DEVELOPMENT REVIEW BOARD
TRANSPORTATION DEVELOPMENT

DRB Project Number: 1002739
Anderson Heights

SUBJECT: Amended Preliminary Plat, Amended Site Plan for Subdivision, Sidewalk Deferral

DATE: March 21, 2018

Designed: DER	Drawn: DER	Checked: DMG	Sheet 1 of 5
Scale: 1" = 100'	Date: 11/20/17	Job: A17022

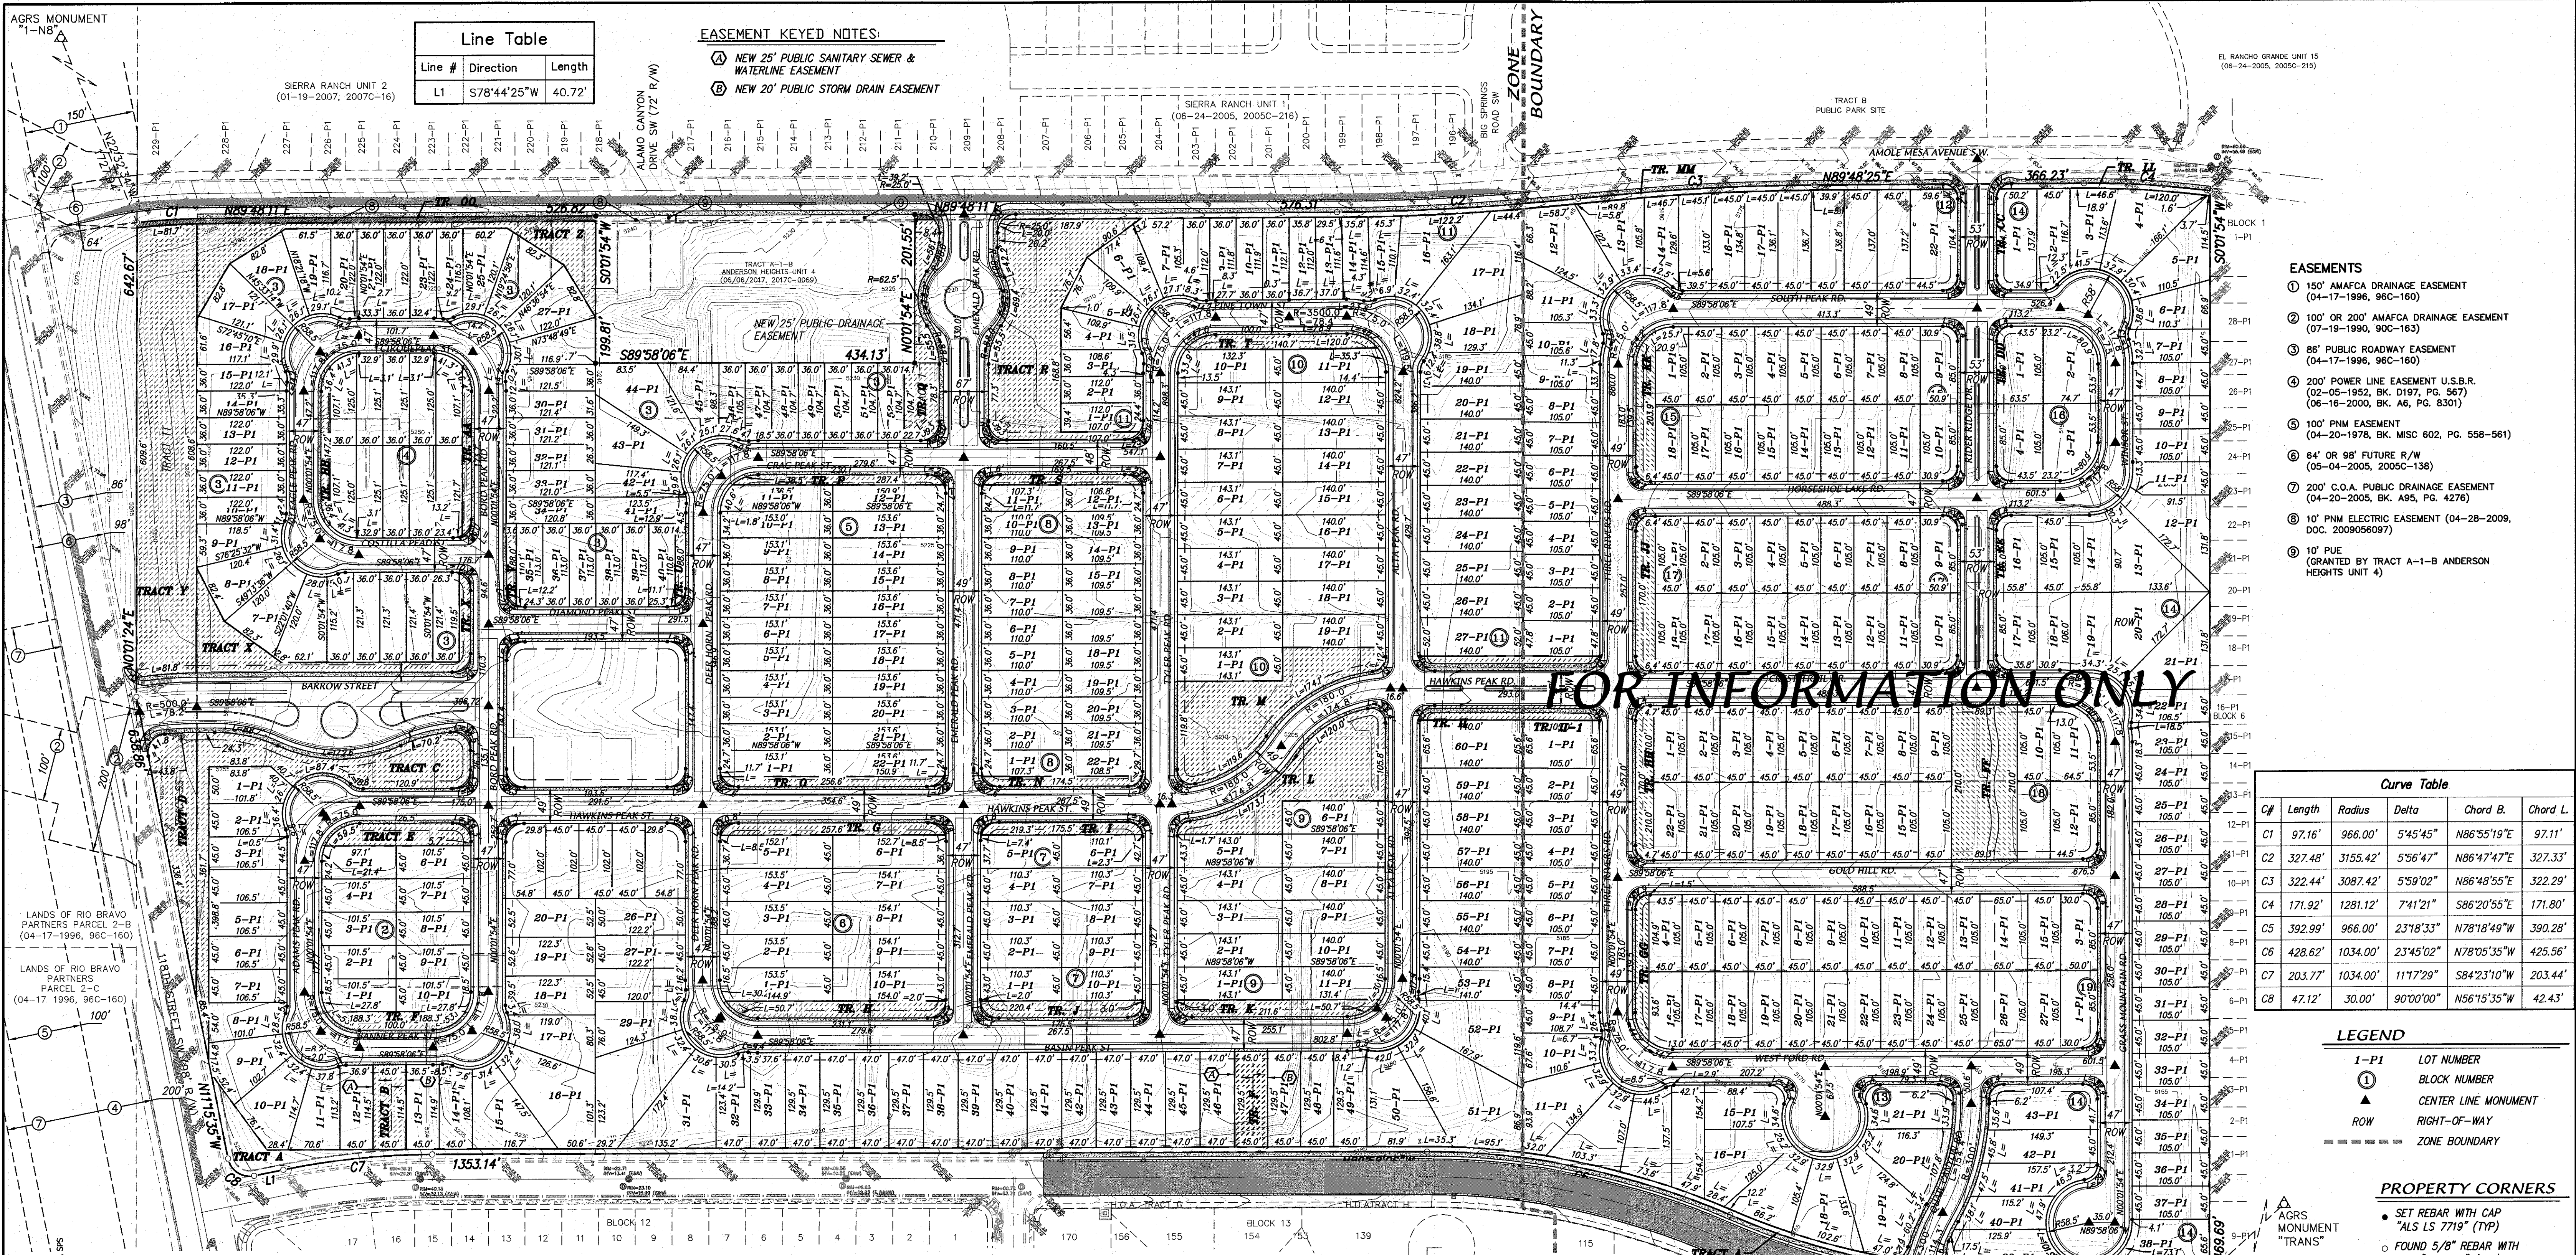
1. Is there a trail in tract II? Add an easement and dimensions.
2. Add a note explaining what the remainder tracts on each block are and who is responsible for maintenance.
3. Make sidewalk in tract AA and BB 6' wide. Provide easement
